Our Case Number: ACP-323094-25

Re: Proposed development at Garrykennedy Inner Harbour
Garrykennedy Inner Harbour, Garrykennedy, Co. Tipperary

Your Ref: **ACP-323094-25**
Our Ref: **177AE Garrykennedy**

177AE Application: Tipperary County Council: Proposed development consists of clearance of the Inner Harbour including removal of abandoned boats, addressing safety concerns in relation to the existing boardwalk by removal of existing and replacement with new floating pontoons for 47 No small boat berths that include facilities to enable wheelchair users to access the water, extension to existing welfare building to provide "changing places" facility, alterations to existing parking to facilitate 4 No recreational vehicle parking spaces with power and water points, updated accessible parking and provision of bike parking / charging facilities: Garrykennedy Inner Harbour, Garrykennedy, County Tipperary.

Figure 6.1: Light Plan of the proposed Inner Harbour

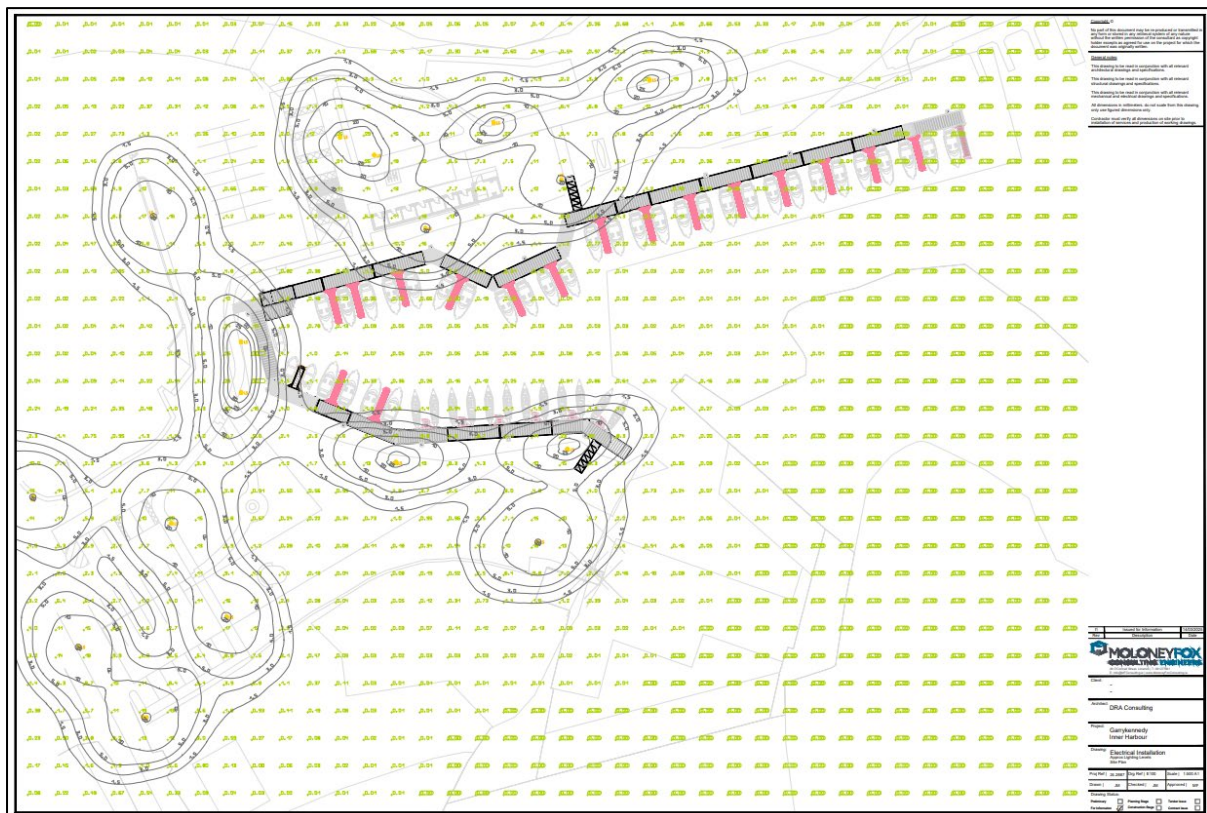
The area of woodland to the east of the site is likely to provide high quality foraging habitat for bats, especially since it is adjacent to the lake. Since the proposed service lighting bollards located on the pontoon at the east end of the inner harbour are facing directly across onto the woodland, it is recommended that the light fixtures on these are cowled in order to ensure that there is no glare directed towards the woodland.
